**Consultation Response from Alan Smith,
KC Waste Strategy (Refuse & Recycling)**

2025/90487 47, Huddersfield Road, Mirfield, WF14 8AE

Change of use and alterations to convert from vacant bank (Class E) to hot food takeaway (sui generis) with installation of extract and ventilation equipment and external alterations to the front and rear elevations

Responding Ref: WPN 25 007

title  
**Proposed**  
Ground Floor Layout

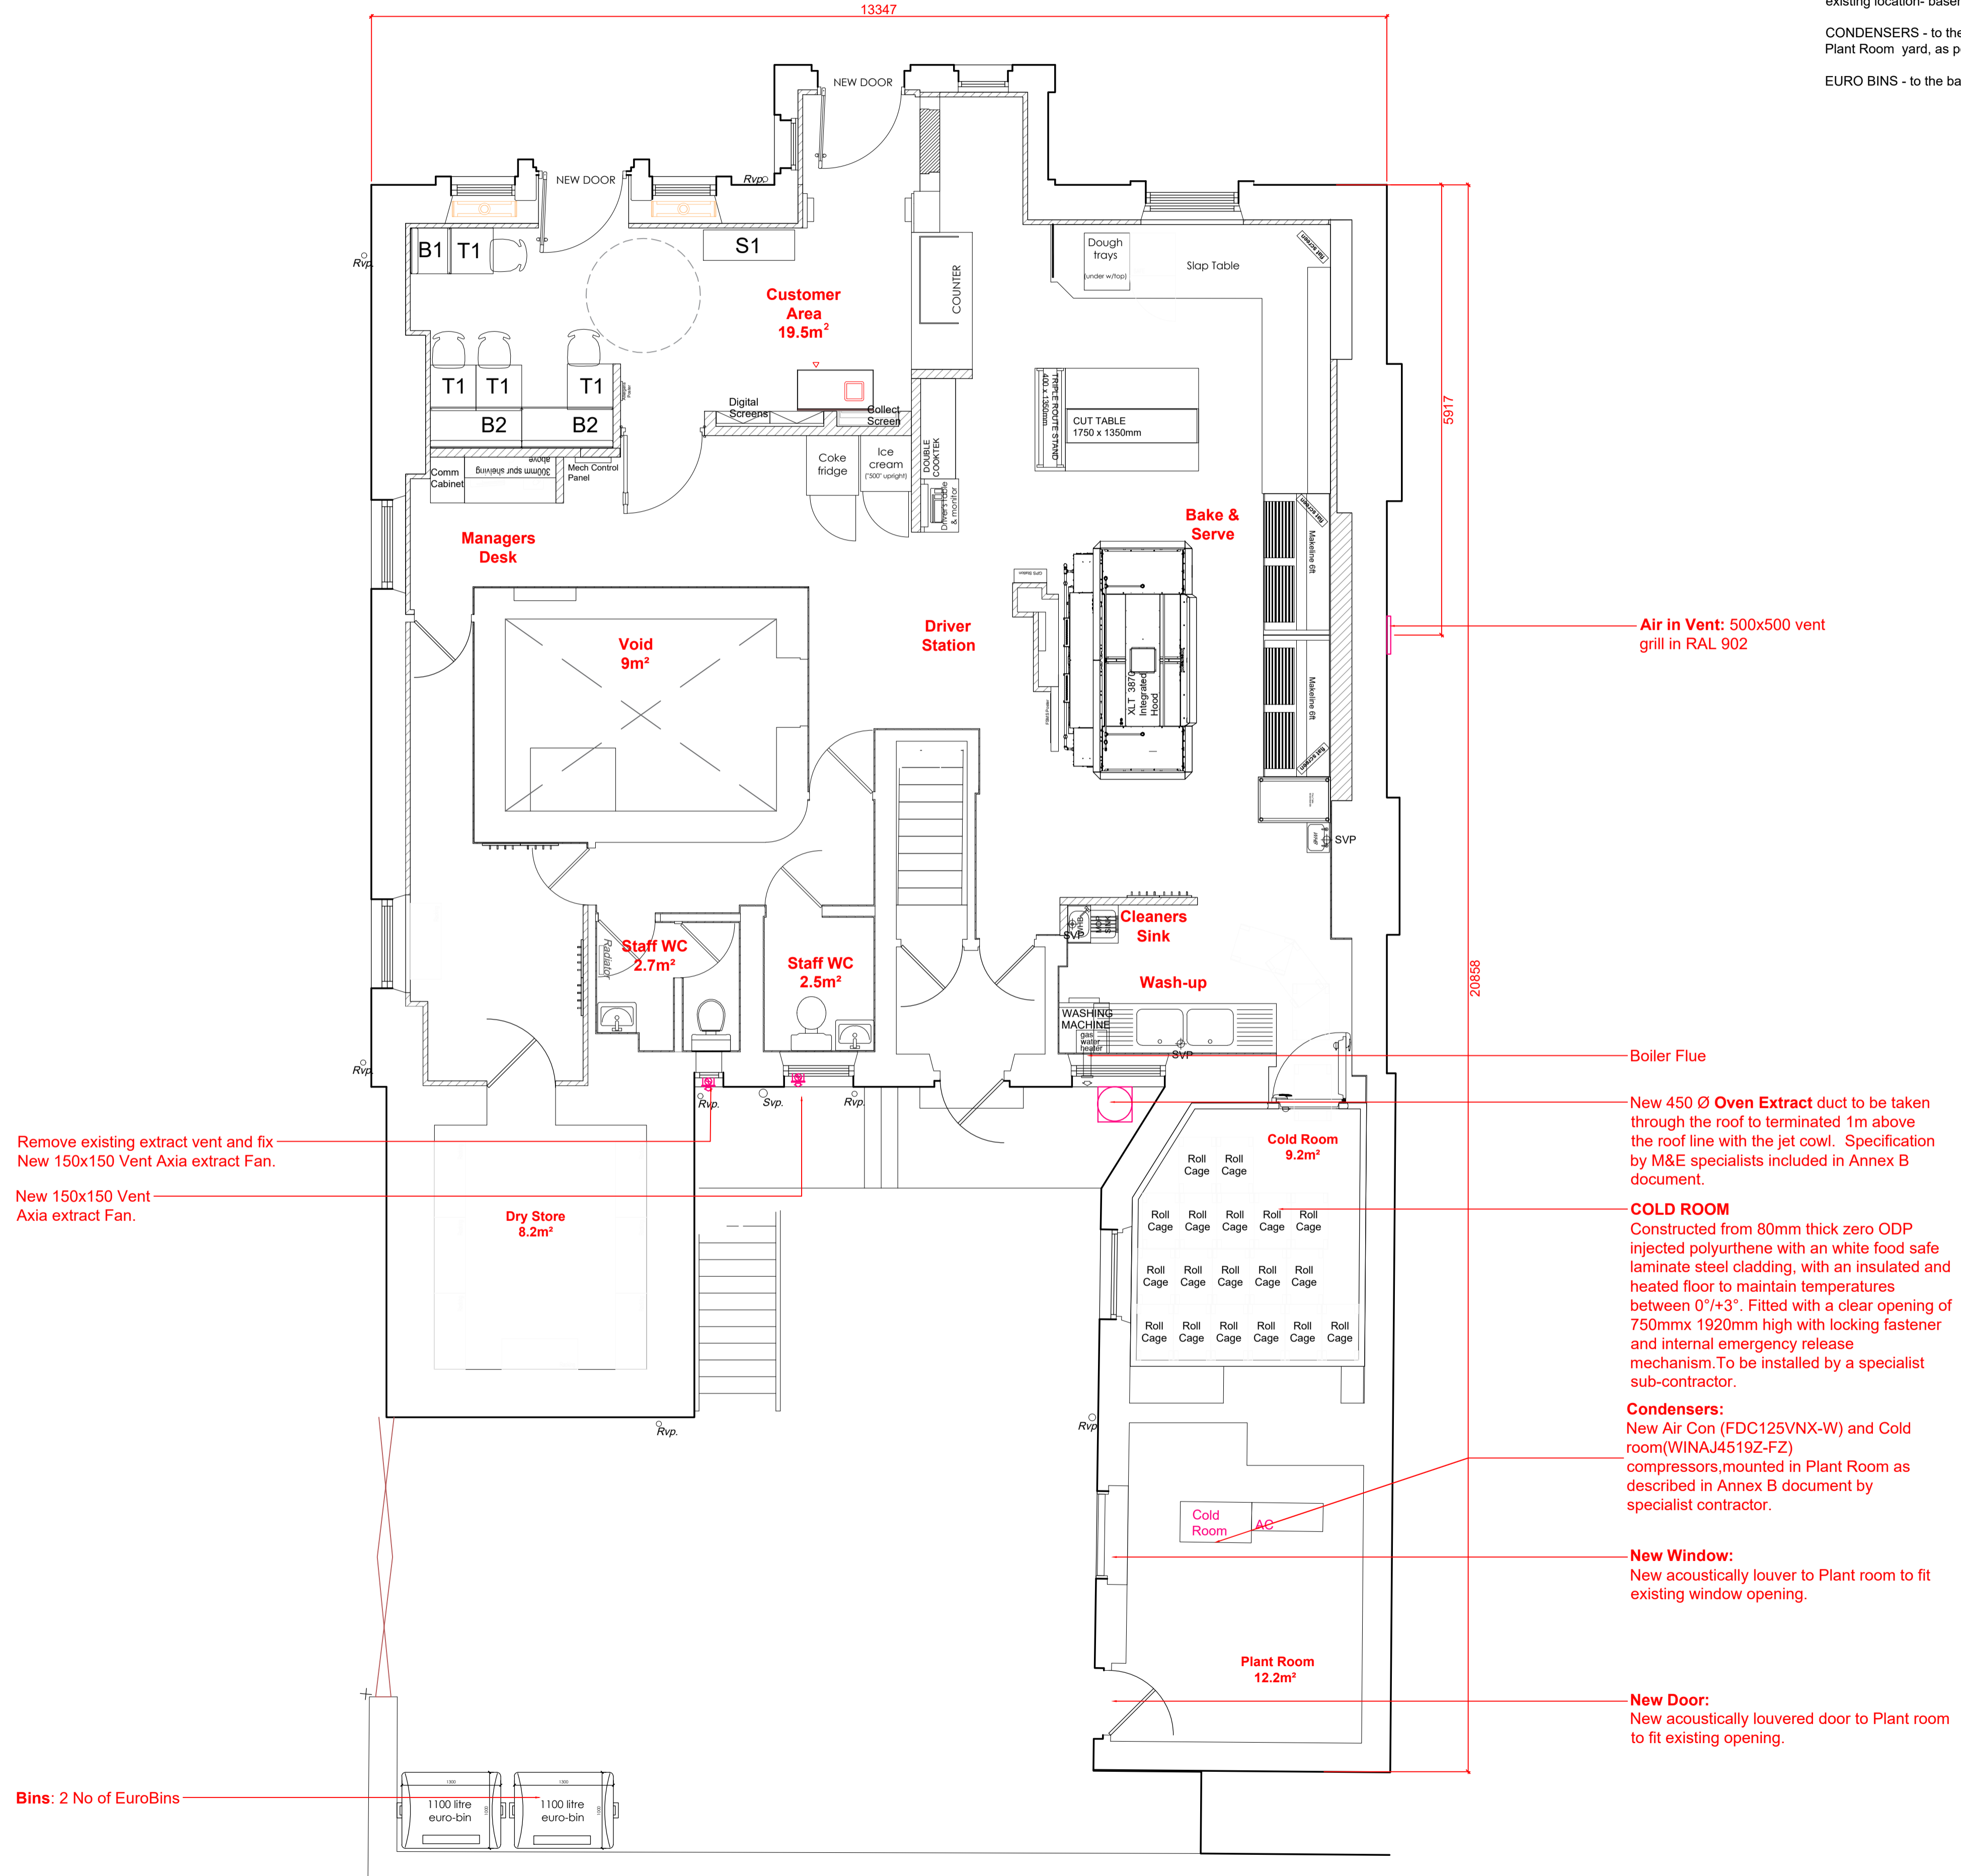
- It is noted that the waste generated will be contained in 2 x 1,100ltr bins and stored in the southwest corner of the site near the gate. I can confirm that this location is suitable for waste storage.

- The bins should be contained within a purpose designed store. Details of bin store construction requirements including screening can be found in the Kirklees Waste Management Design Guide 2020. The bin store should be secure to prevent theft, unauthorised use / fly tipping, arson or rough sleeping.

- Access from the bin storage area to the Bin Collection Point on Trinity Street next to the highway should be constructed to withstand point loading and movement, impacts of larger bins over time, and to resist future rutting, pitting, cracking or other such surface degradation that would impair bin manoeuvring. Wheeled bins must not be permanently stored on the pavement or highway on Trinity Street.
